From: [REDACTED]
To: [Steeple Renewables Project](#)
Cc: [Midlands.splan@nra.gov.uk](#)
Subject: Historic England response to Rule 17 letter dated 02/04/2026
Date: 08 April 2026 16:59:24
Attachments: [image255549.jpg](#)

Application by Steeple Solar Farm Limited for an order granting development consent for the Steeple Renewables Project

Request for further information

Your ref: EN010163

| DRAWING TITLE ES FIGURE 2.1 INDICATIVE SITE LAYOUT | | | | | |

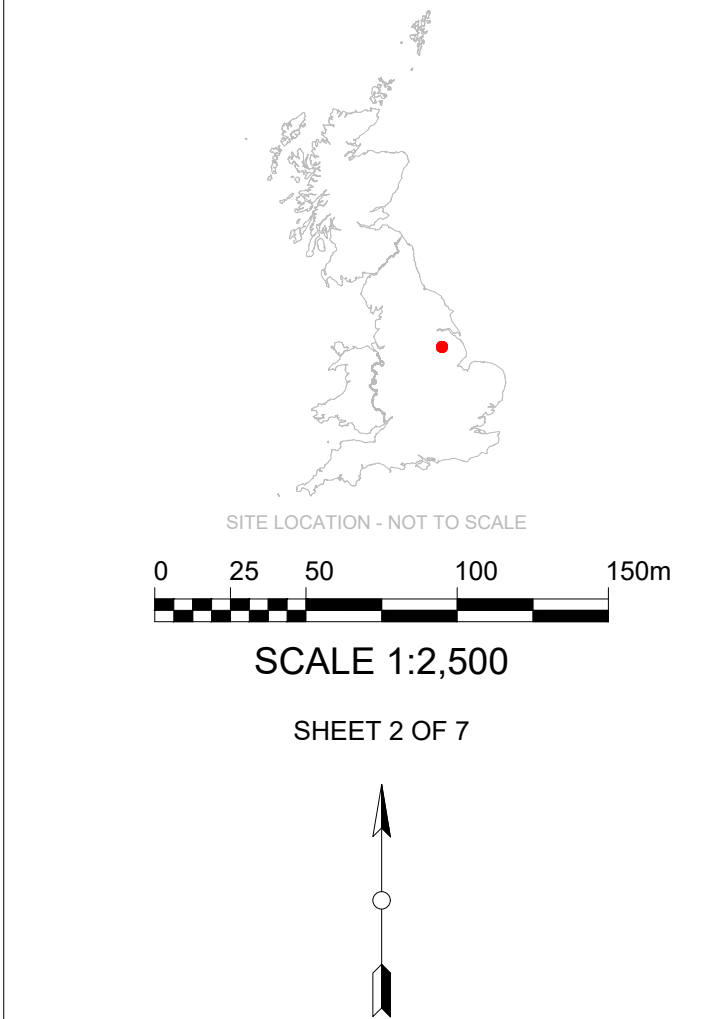
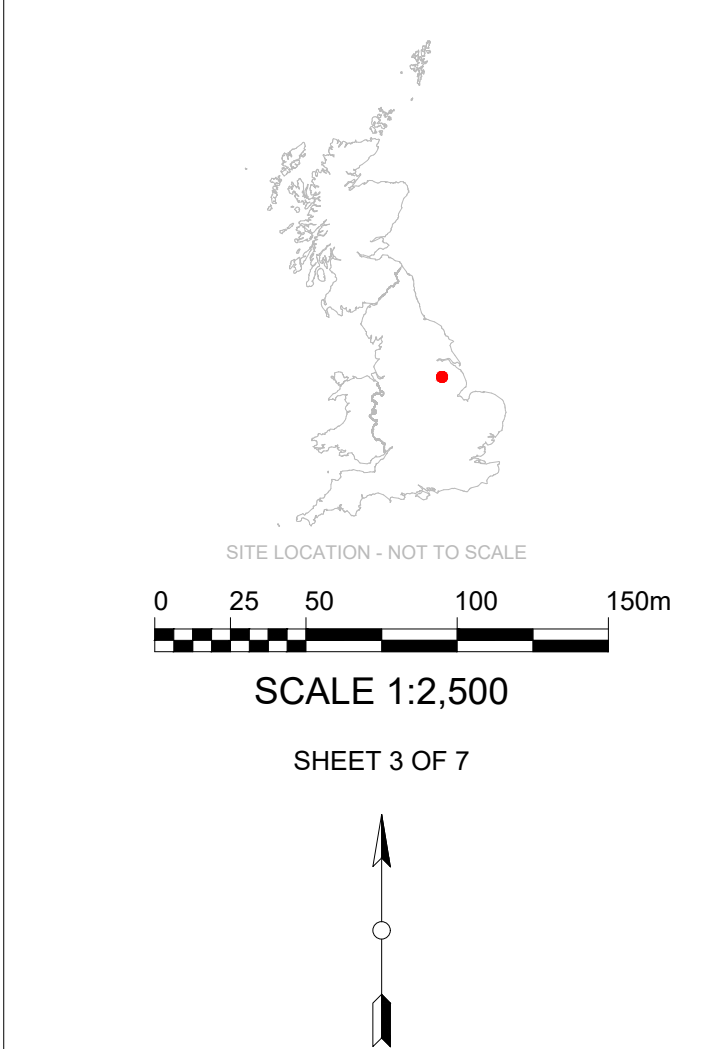
The experience of views to the tower of St Peter and St Paul provides both orientation and a point of contrast and reflection between the abandoned and living settlements. It is regrettable that the applicant did not explore these issues with us earlier in the pre-application process, and that at this late stage an opportunity to address avoidable harm to designated heritage assets of national importance remains unaddressed in scheme design. This position is reiterated in the final signed statement of common ground. Our position remains that harm in respect to the designated heritage assets could be addressed through relocation of BESS capacity and elements of solar array.

Alternative layout drawings and supporting [REDACTED] ons would provide the decision maker with the opportunity to consider an alternation to address the above issue.
